PLANNING CONSULTATION RESPONSE

Application No	2026/0355
Proposal	(RETROSPECTIVE) Variation of condition 2 (Approved Plans) of application 2024/0699: Demolition of existing buildings and erection of 5no. bungalows, formation of new access and associated works.
Address	Royston Working Mens Club, 52 Church Street, Royston, Barnsley, S71 4QU
Date of Consultation Reply	16/09/2026
Consultee	Katie Lawrence, Planning Ecologist

Drawing  
Title:  
SITE PLAN

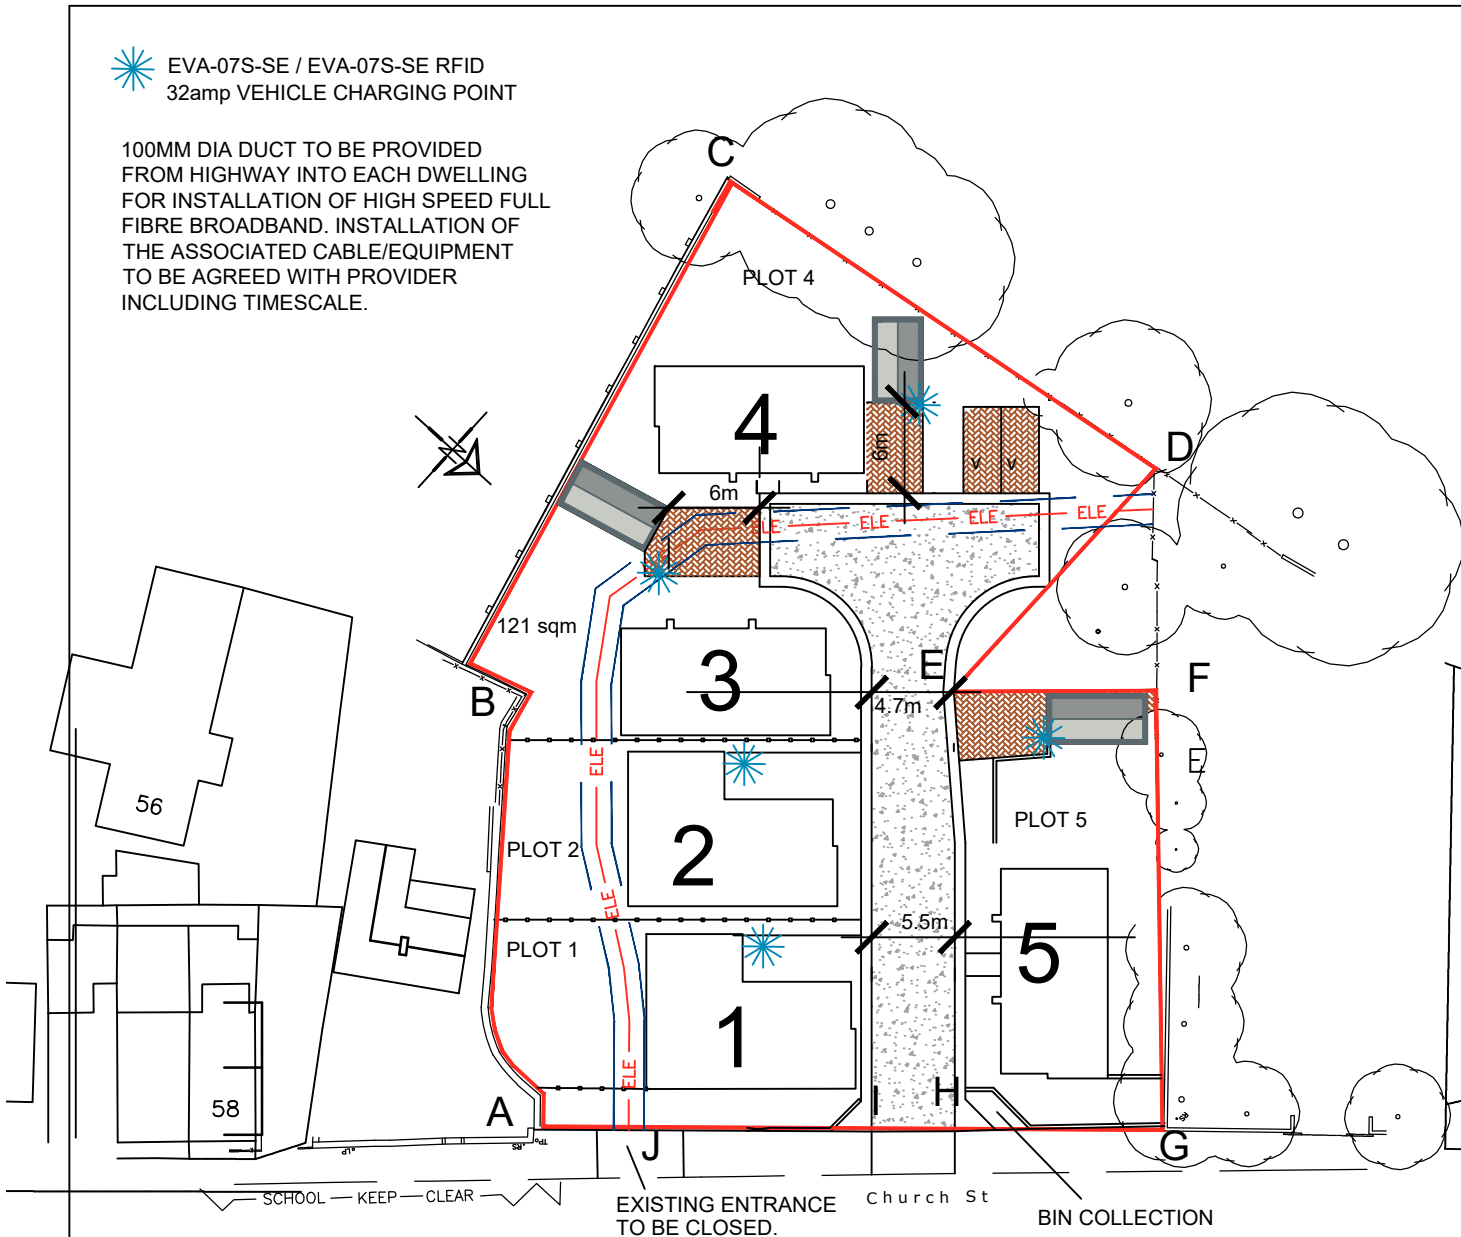
In addition to amended BNG documents submitted with the above application, the developer provided a proposed site plan (ref: 23-277, 06, REV F) which indicates locations of integral bat and swift boxes on the proposed dwellings and hedgehog access points within fencing on site. This is satisfactory.
